ENG-SP20008-R3-TIS-redlines.pdf Markup Summary

Figure 3
Sight Distance Analysis
Homestead North Phase 1 (LSC #204380)

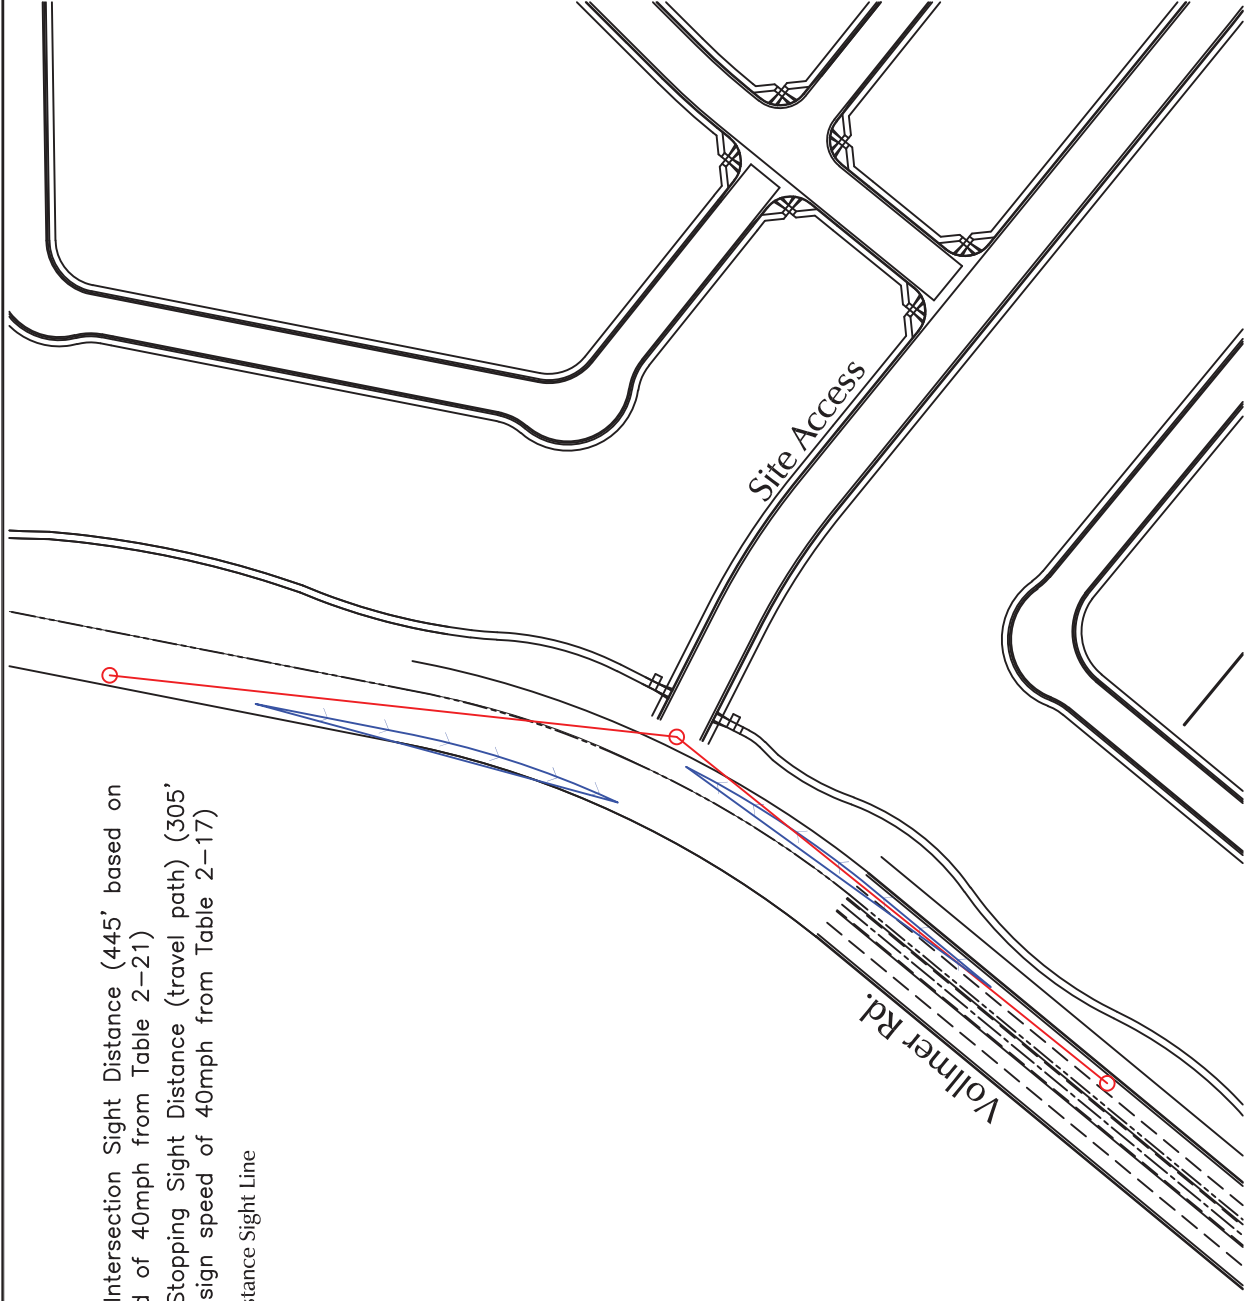
Will this be a continuous accel-decel lane on Vollmer?

Figure 3
LSC # 074230

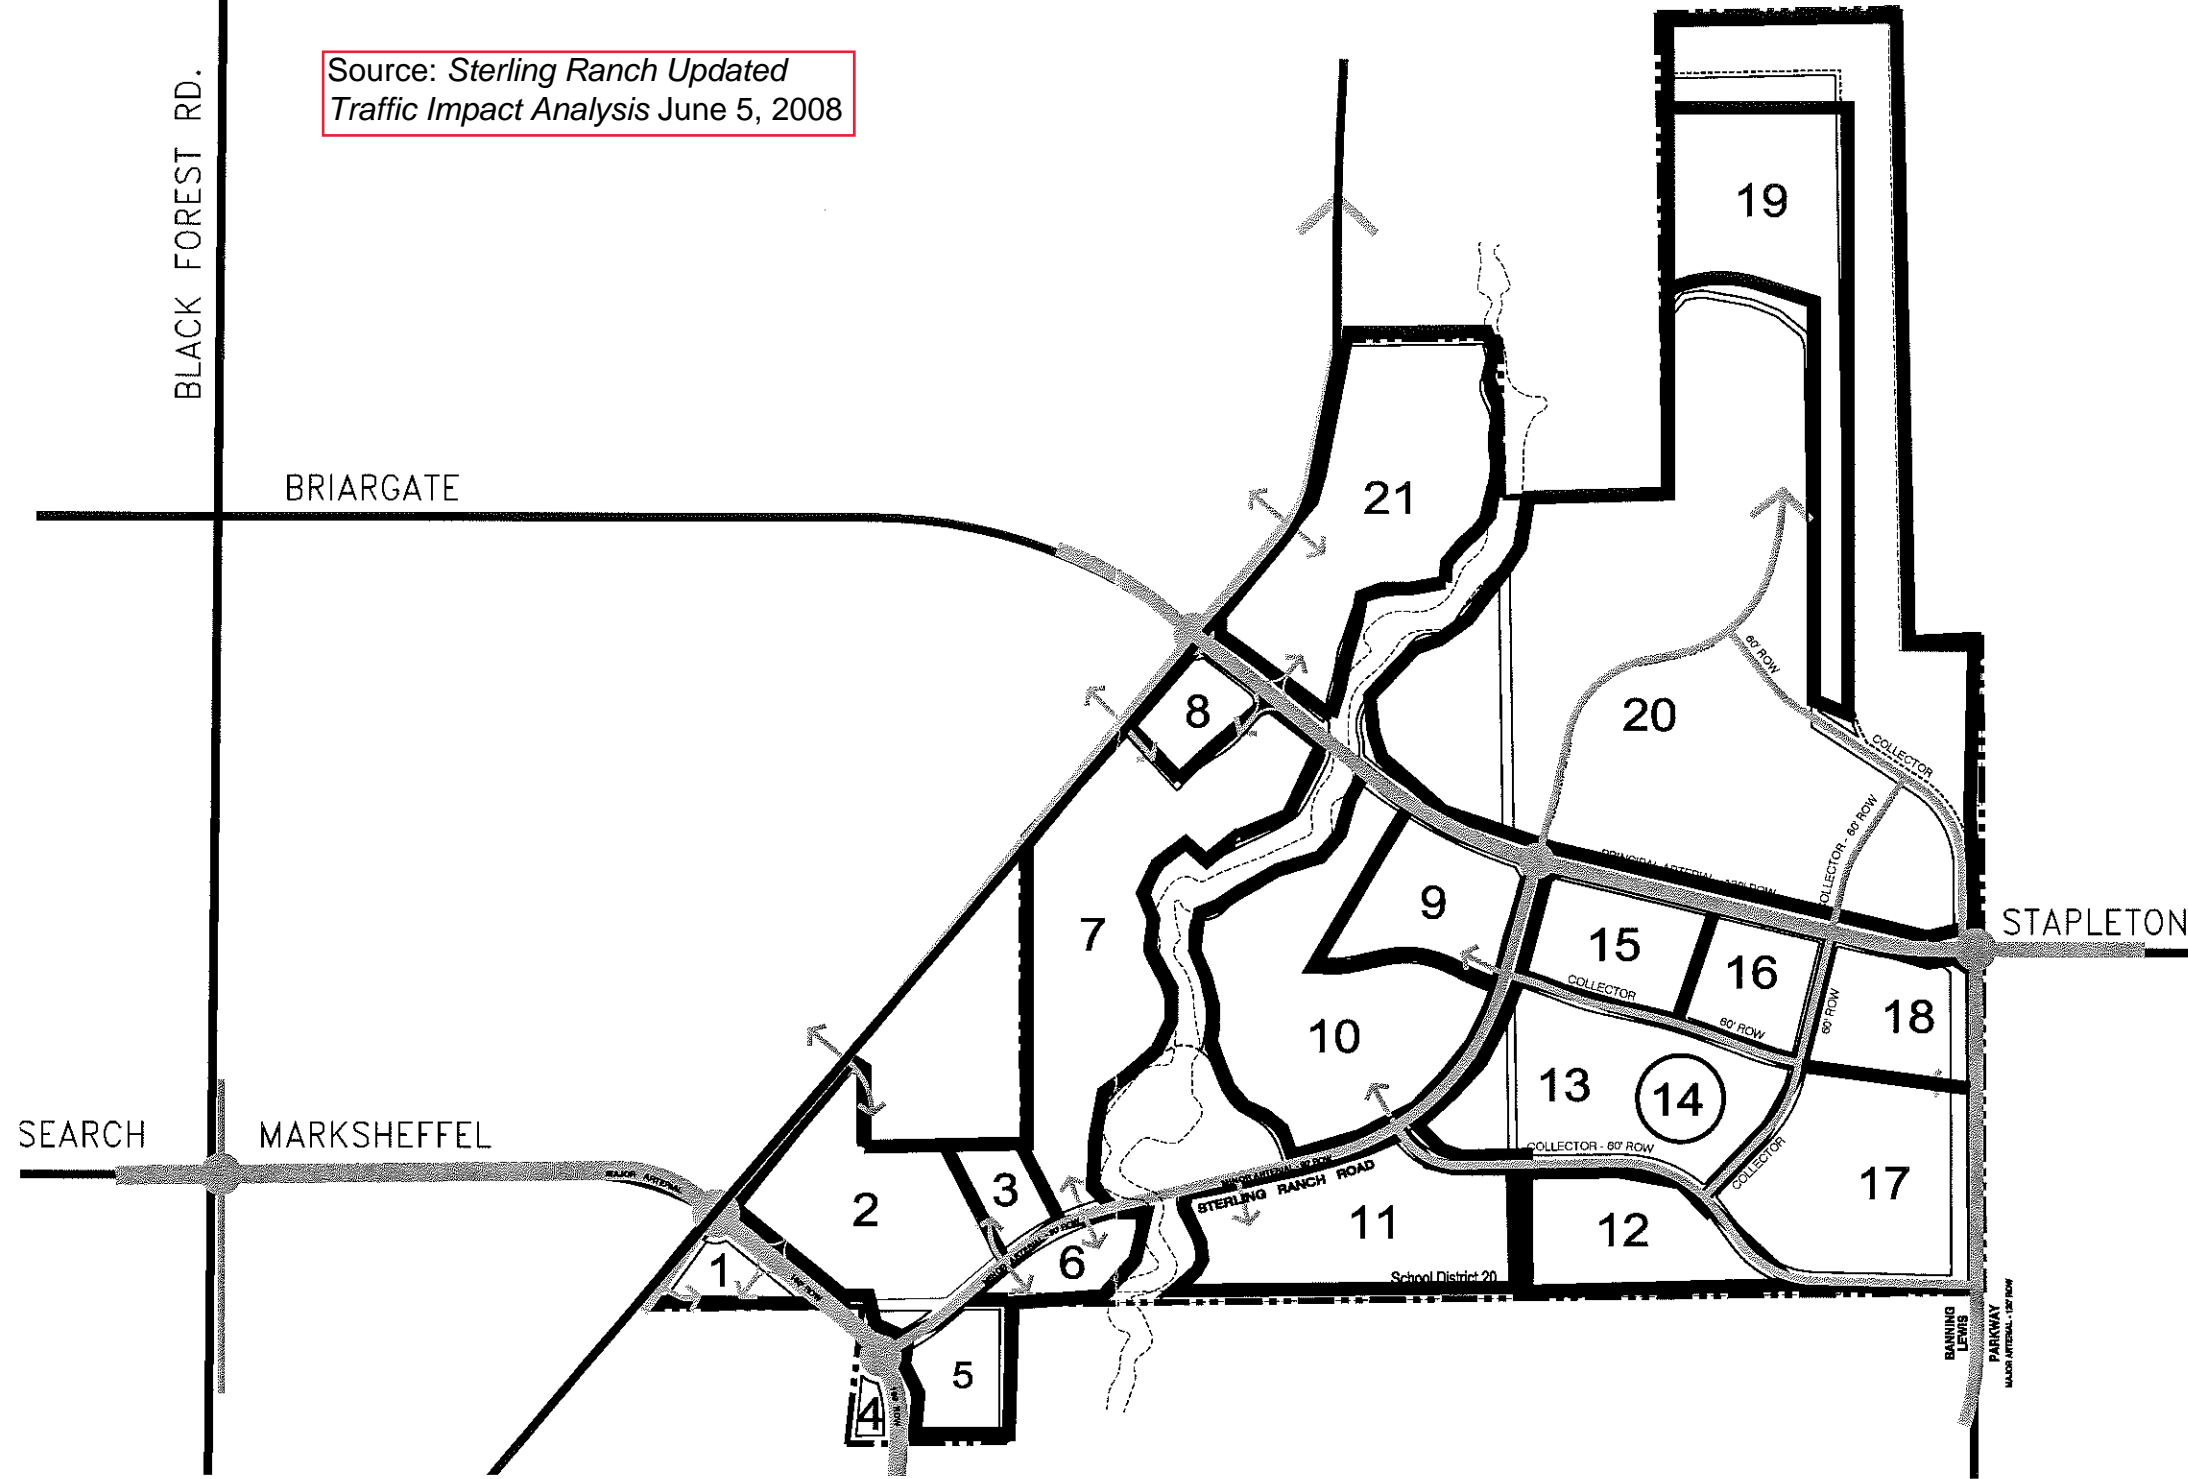
(Insert Sterling Ranch Filing 2 Fig. 23, show V6 and V7.)
